CITY OF ALBUQUERQUE

**Planning Department
Transportation Development Services Section**

Re: Certification Submittal for Final Building Certificate of Occupancy for
Premier Concrete, [C-17 / D13B2]
8400 Firestone Lane
Architect's Stamp Dated 01/05/07

**Re: Premier Concrete
8400 Firestone Rd
Approval of Permanent Certificate of Occupancy (C.O.)
Engineer's Stamp dated 5/5/2006 (C-17/D13B2)
Certification dated 1/16/2007**

DRAINAGE PLAN

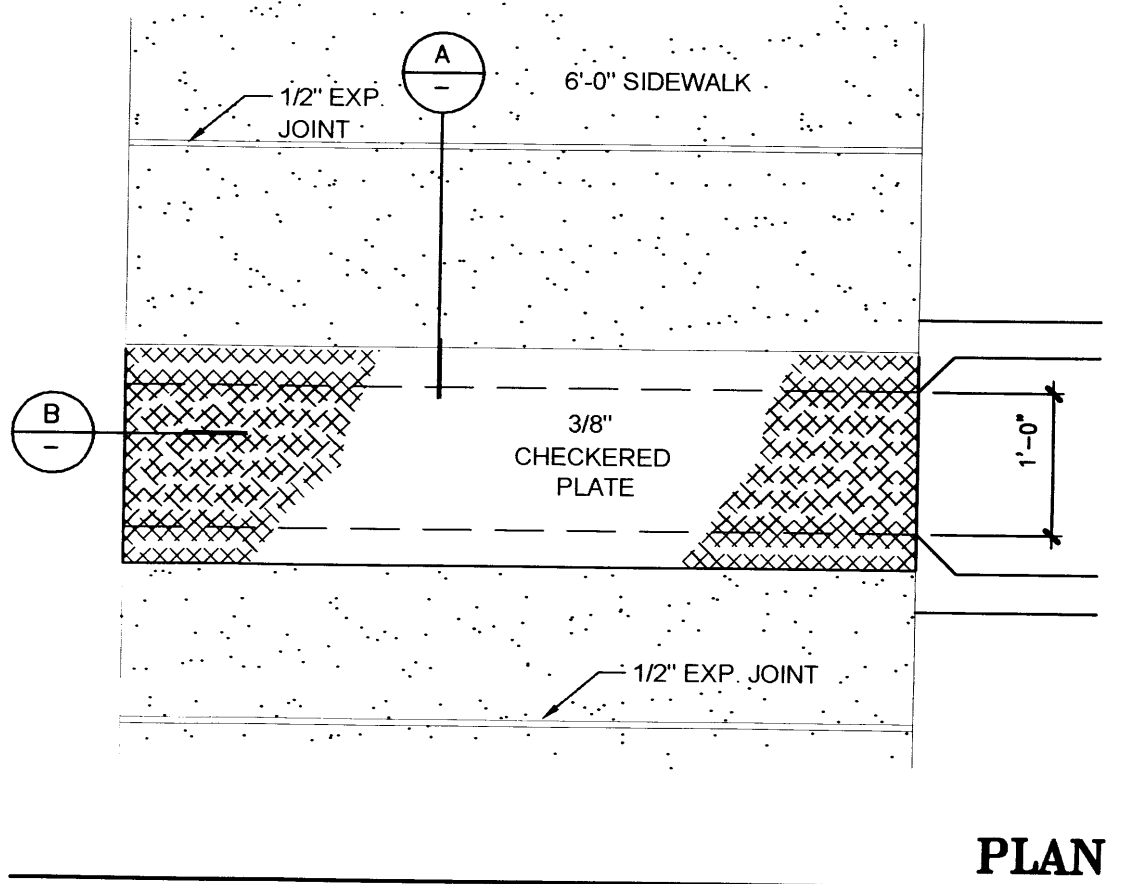
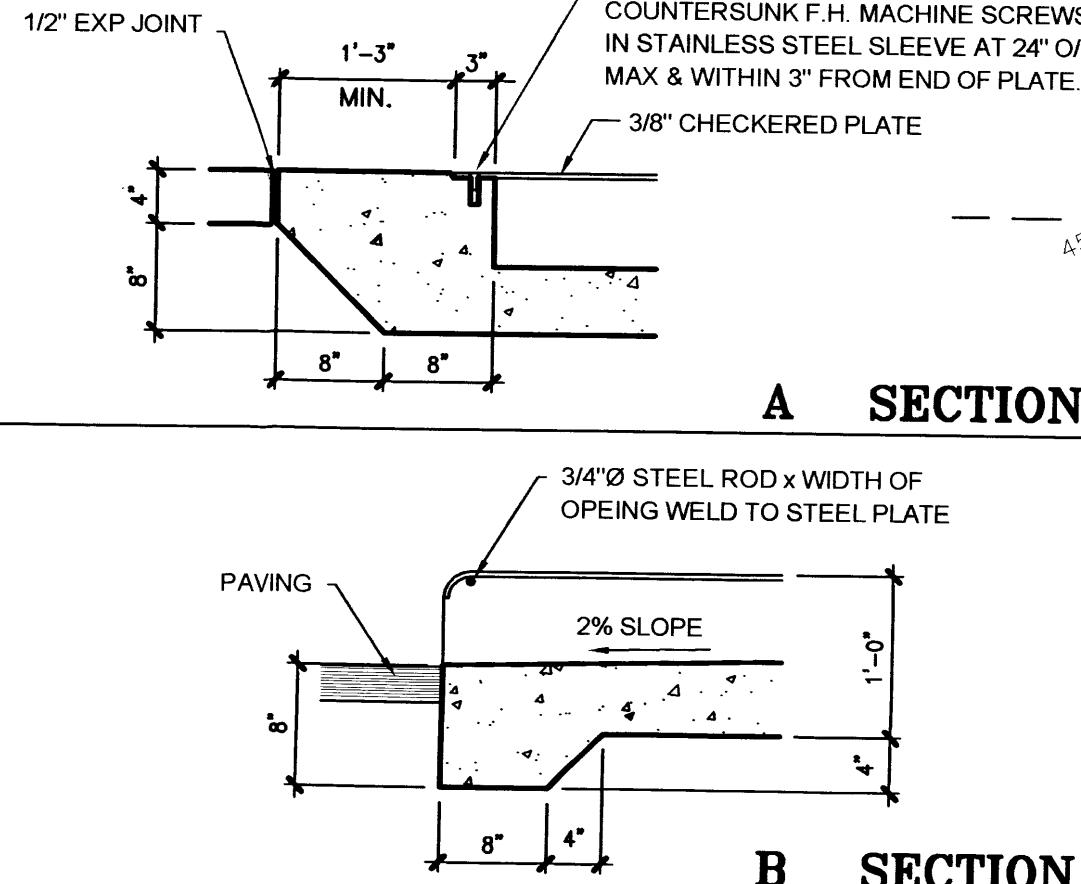
Based upon the information provided in your submittal received 3-13-06,
the above referenced plan cannot be approved for Building Permit until the
following comments are addressed:

1. Two proposed ground elevations are provided; based on the existing elevations, this will require significant earthwork. Please provide more information regarding the proposed grading in this area.
2. Provide a swale detail.
3. Is the entire site designed to discharge to Firestone Road? The southernmost portion of the site currently appears to discharge to Lot 14-A-1.

NATIONAL SANITARY SUPPLY
GRADING AND DRAINAGE PLAN

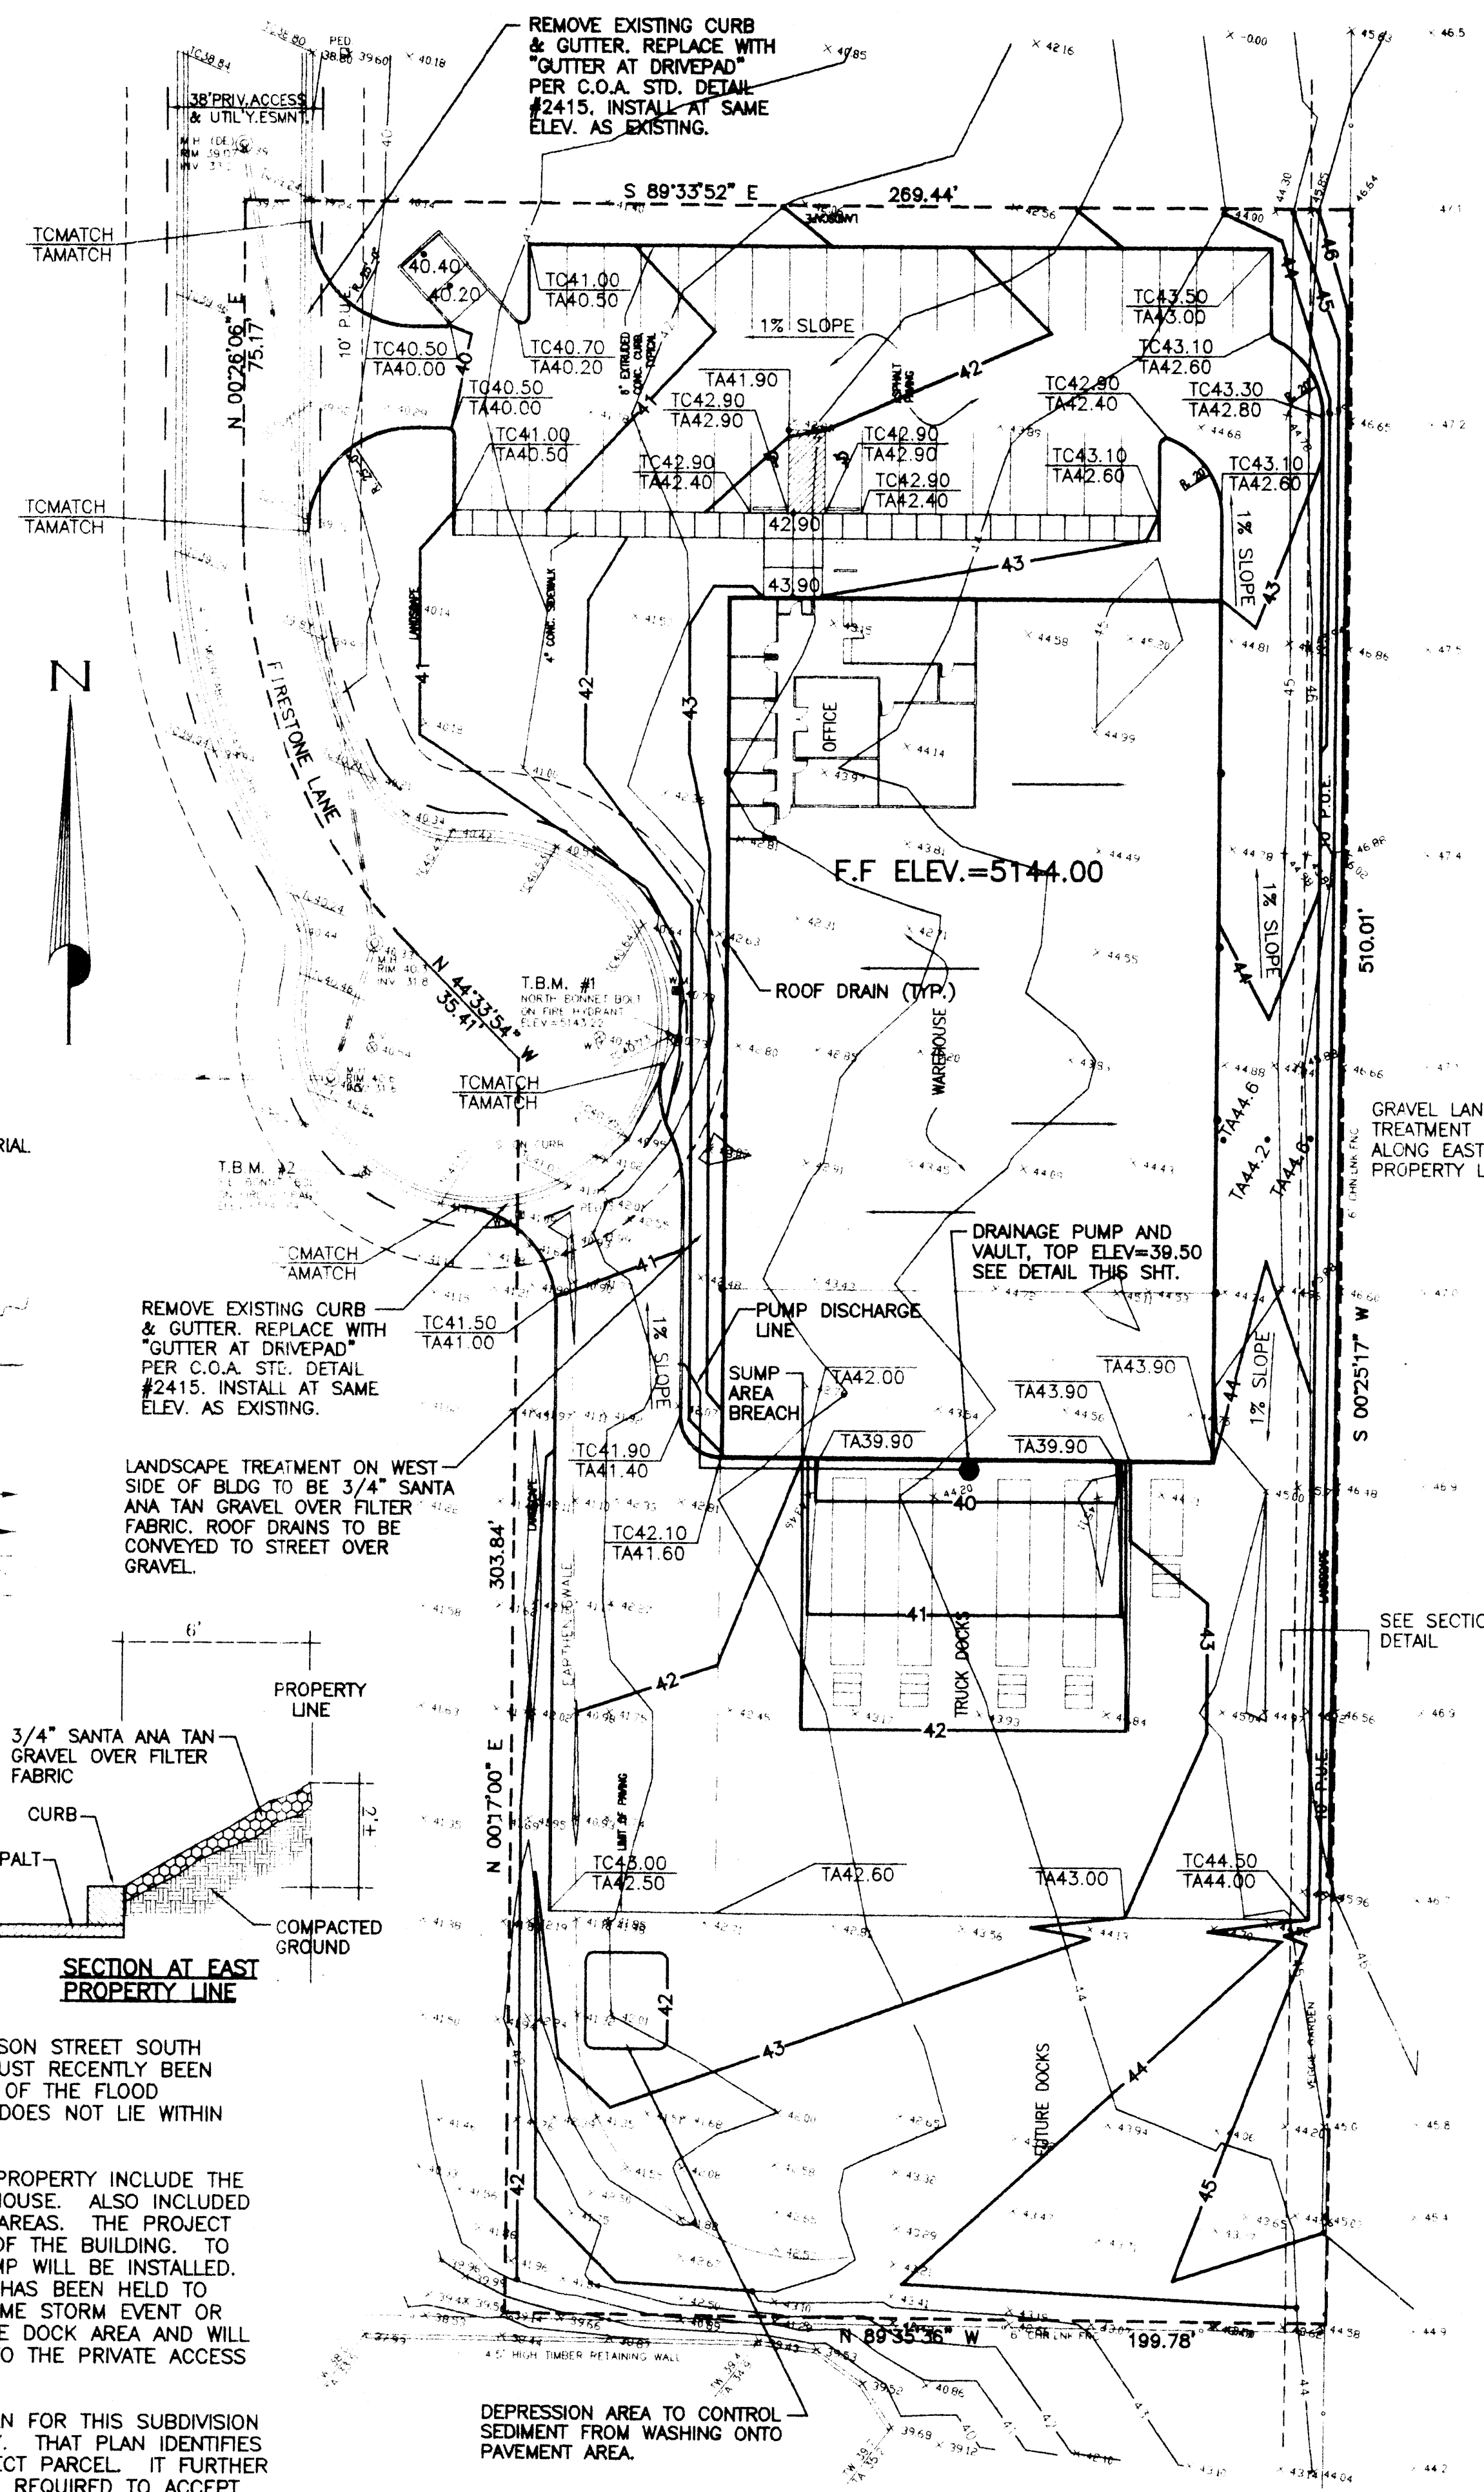
- ✓ 1. Roof drains on the west side of building must be routed to the asphalt area. Developed run-off is not allowed over the public R/W.
- ✓ 2. What type of sediment and erosion control do you propose for the future dock area?
- ✓ 3. Identify the slope on each of your proposed swales.
- ✓ 4. How will you accept and pass the off-site flows from the east?

1. Runoff from the roof drains on the west side of the building will be conveyed over the proposed landscape treatment to the private access easement. The landscape treatment is a gravel over a filter fabric. A note was added to the plan to identify this.
2. A depression area was added to the plan to help control sediment from washing on the paved surfaces.
3. The slope of each swale was added to the plan.
4. The off-site flows enter the site as "sheet flow". They will be conveyed over the surface of the landscape buffer provided along the eastern property line. A detail was added to the plan to show this condition.
